6 November 2018

Planning Services
Department of Planning and Environment
GPO Box 39
Sydney NSW 2001
ATTENTION:
Director Social and Other Infrastructure Assessments

**Physical Education Precinct for St Joseph's College,
Mark Street Hunter's Hill
(SSD 8970) Notice of Exhibition**

TREE RETENTION AND REMOVAL PLAN - LUKE STREET

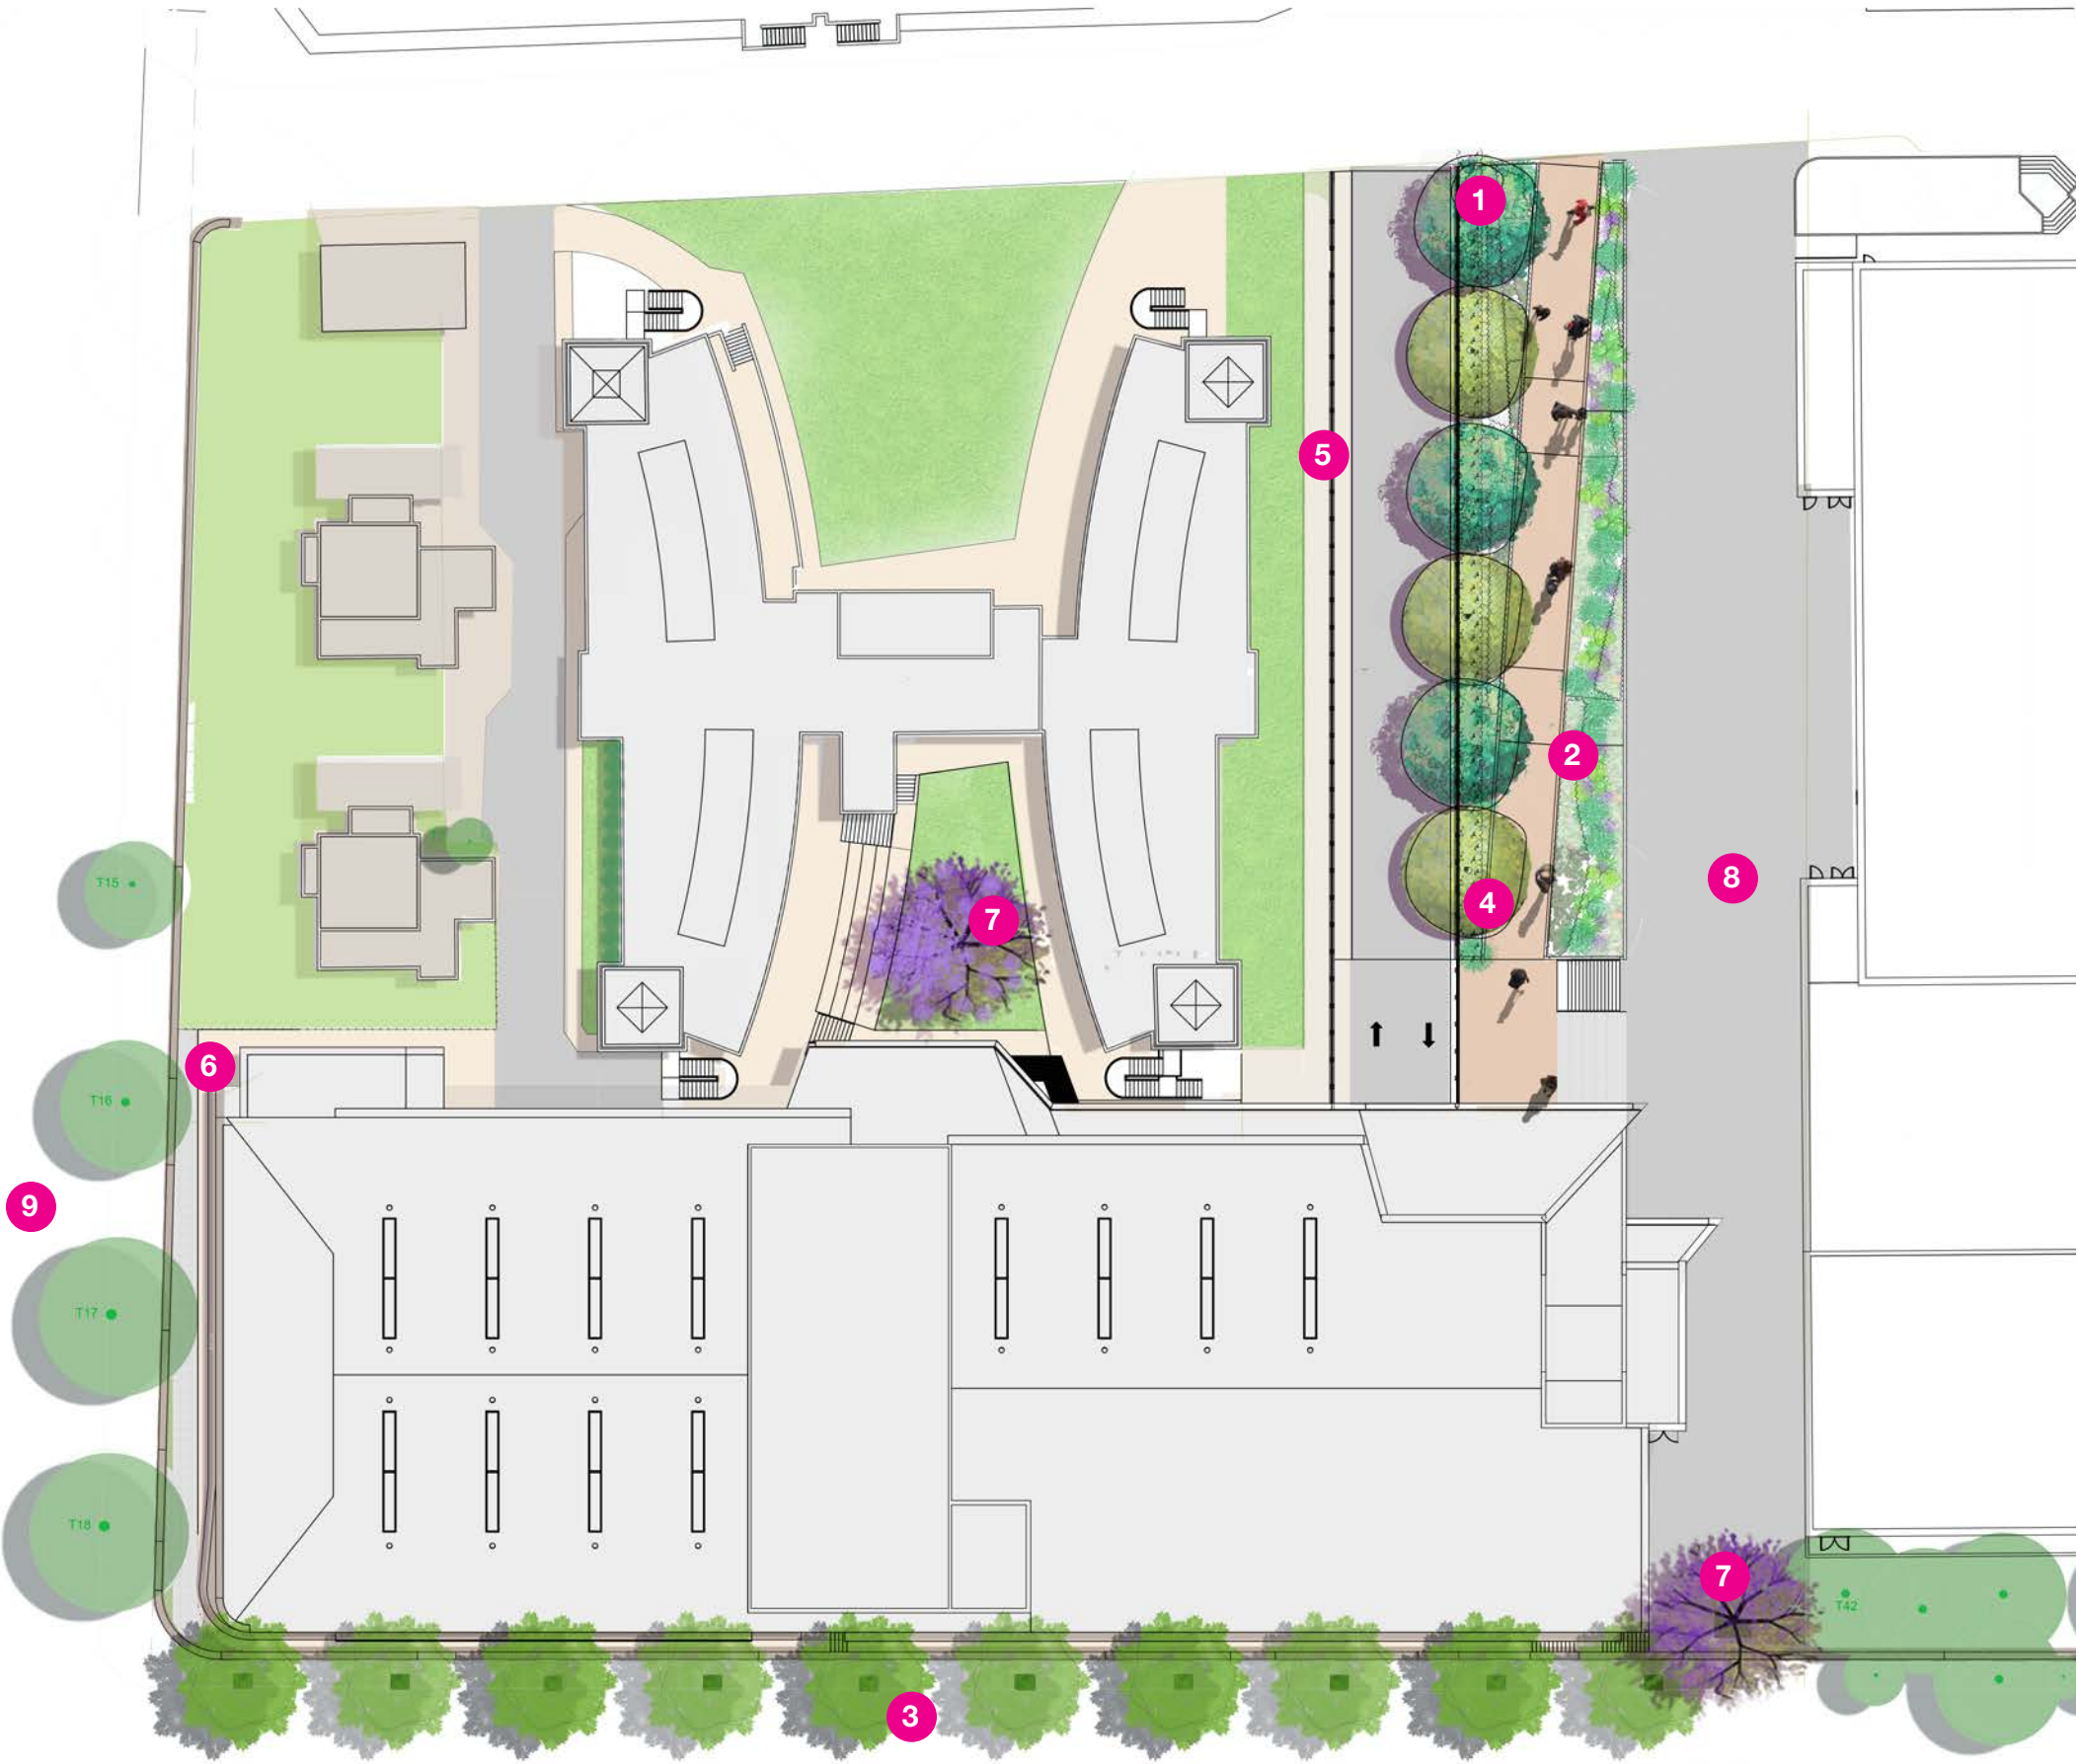
I am writing to make a submission on the Physical Education Precinct for St Joseph's College, Mark St Hunters Hill. As a long-term resident of Luke St, I am concerned that the Physical Education Precinct SSD 8970 will lead to the destruction of three crimson bottle brush trees (callistemons). These trees are old and well established and approximately 6-7 metres in height. They are frequented by Australian native birds on a daily basis, including king parrots, rainbow lorikeets and rosellas. I understand that native trees are protected. Adjacent to the bottle brush trees is a mature jacaranda tree. I and other local residents are concerned that these trees will be destroyed to the detriment of local fauna and with loss of the aesthetic of Australian flora.

The stone wall that lines Luke St is also very lovely. This wall is continuous with the wall in Gladesville Rd. The integrity of this wall is important for historic and heritage purposes. It would be a great shame if this was lost due to the proposed works of the Physical Education Precinct.
